Our reference: ECM: 9783432  
Contact: Kathryn Saunders  
Telephone: (02) 4732 8567

12 November 2021

**Request for Advice – Request for Further Information for Oakdale West Estate Stage 3 - SSD-9794683 at 2 Aldington Road Kemps Creek**

01 Carpark Tree Pit System
Detailed Plan - Scale 1:100 @ A1

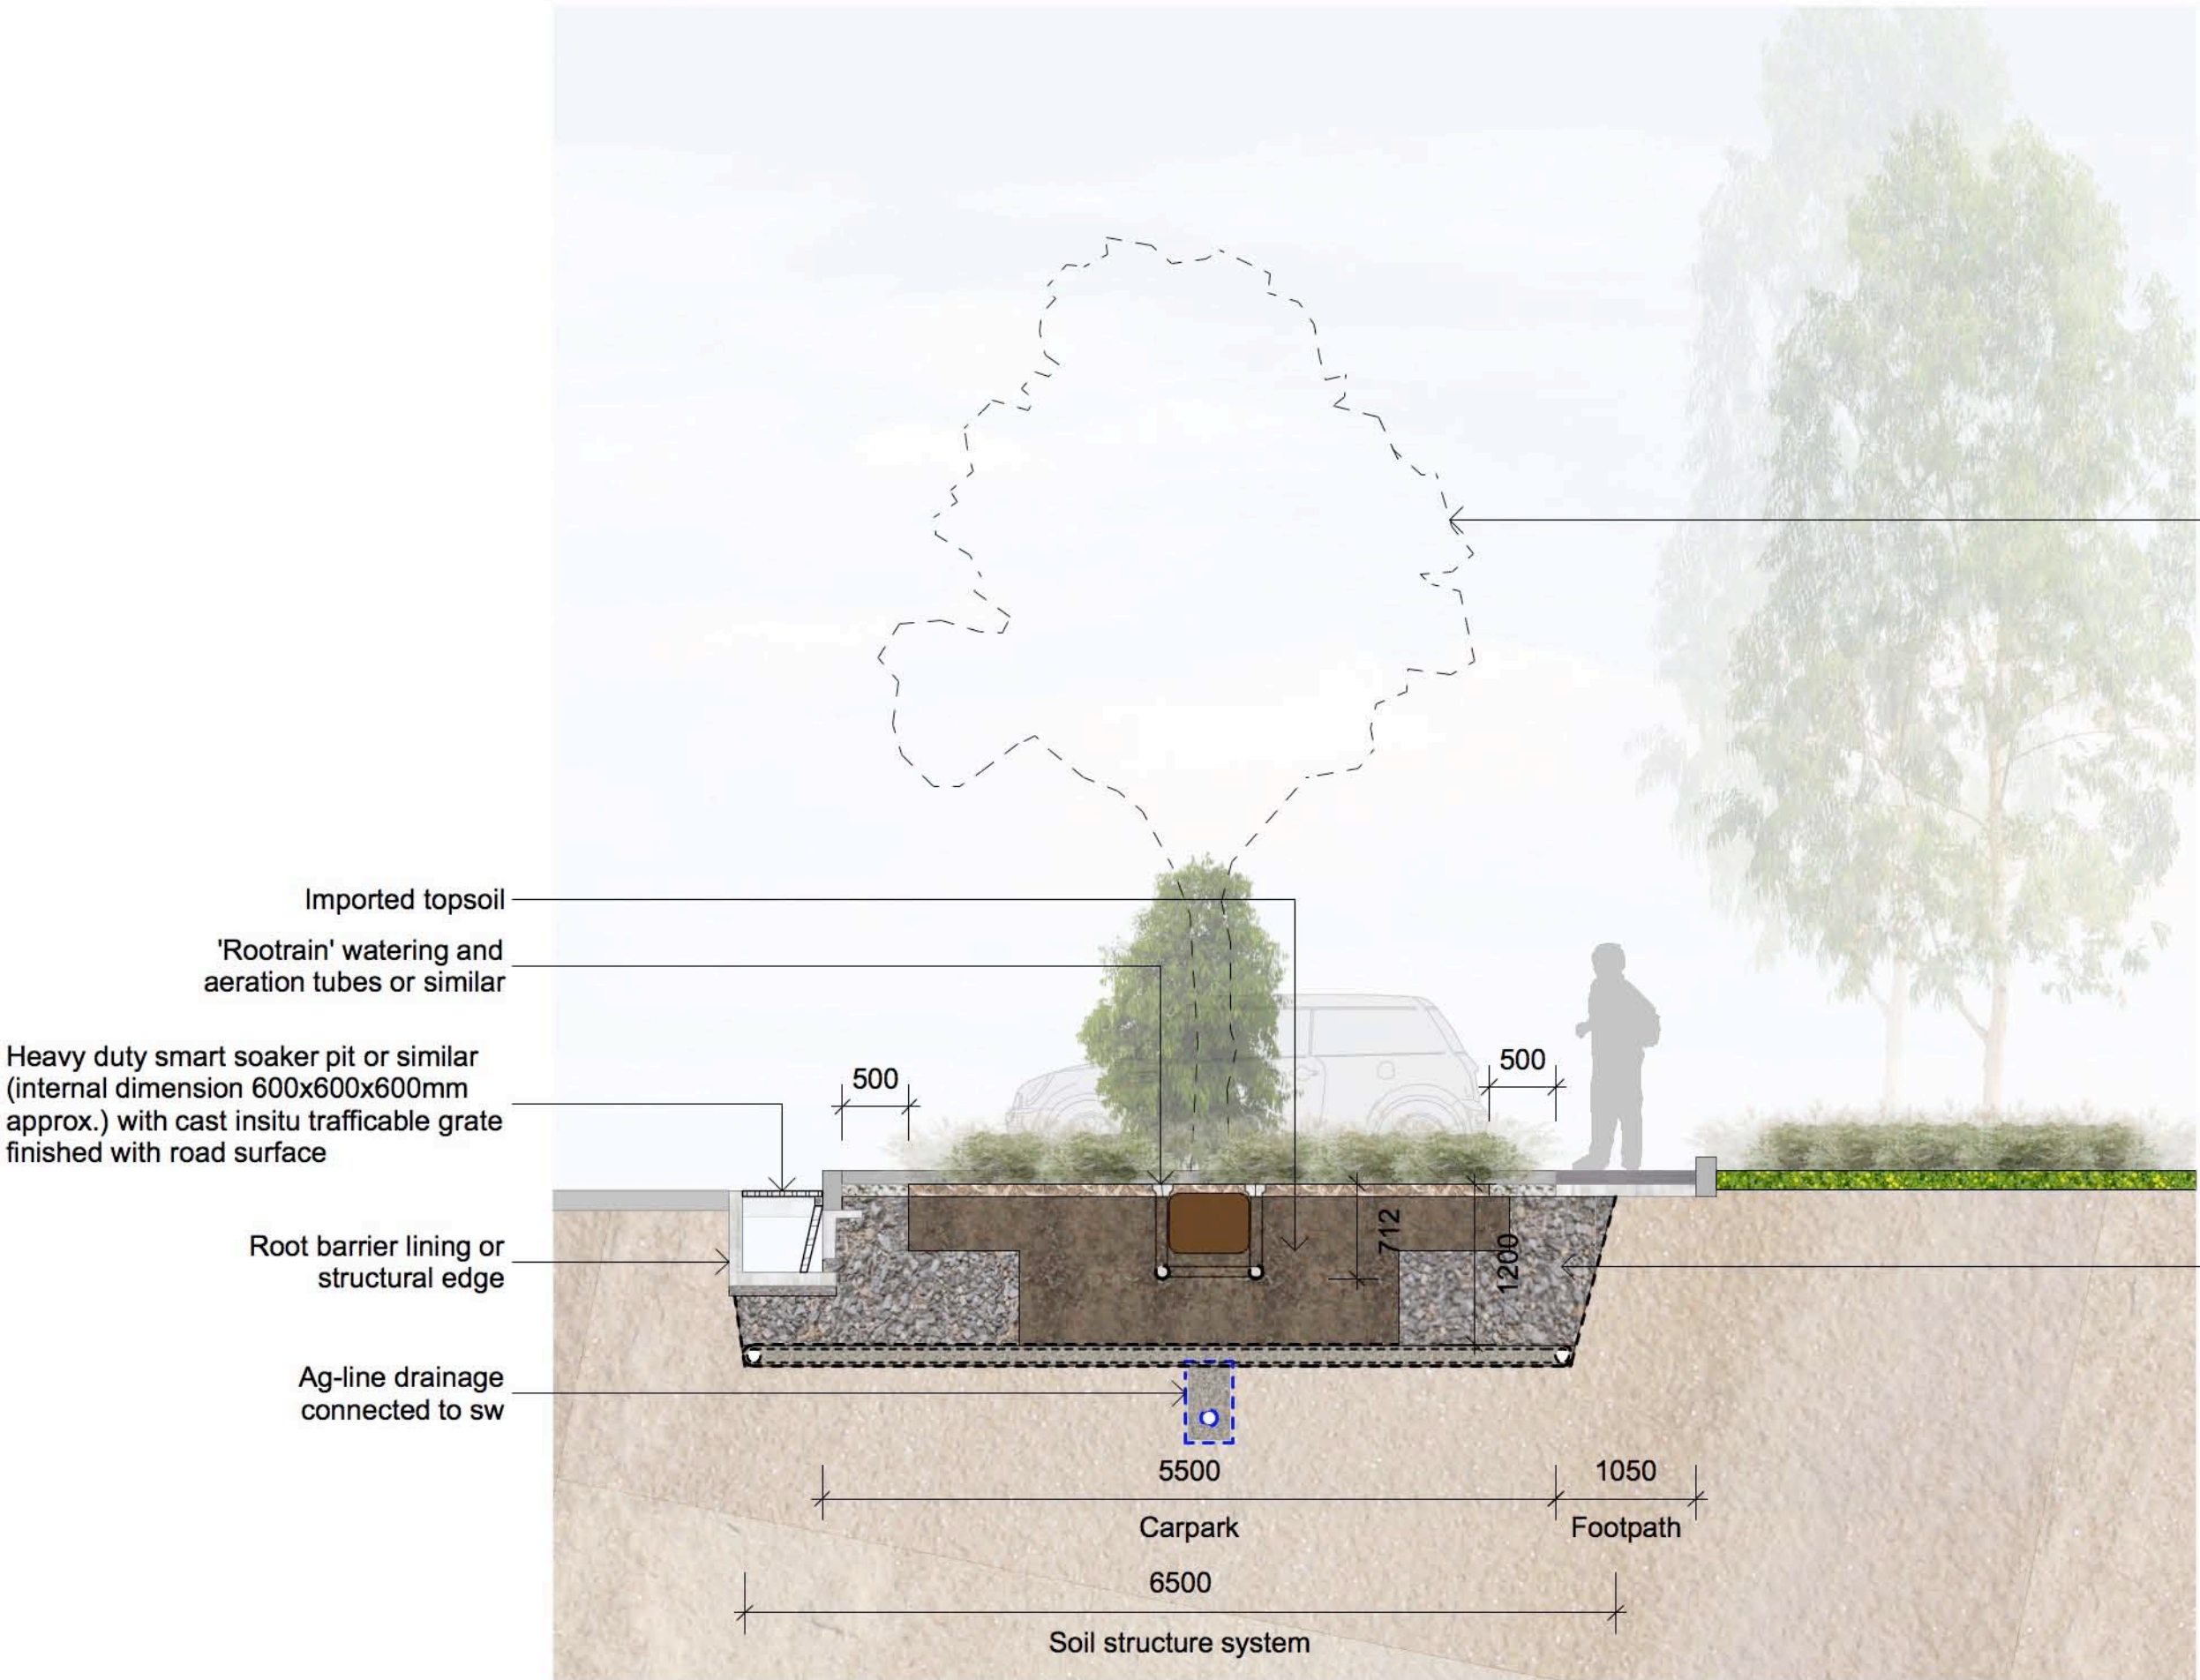
- Tree plantings in the pavement at Lot 2D and carpark areas were previously supported, provided that a suitably qualified and experienced arborist specifies the engineered tree pit details including structural soil volumes and materials, based on proposed species. This was suggested so as to ensure the best possible growing conditions for long term tree health and viability (refer sheet LSK.200)
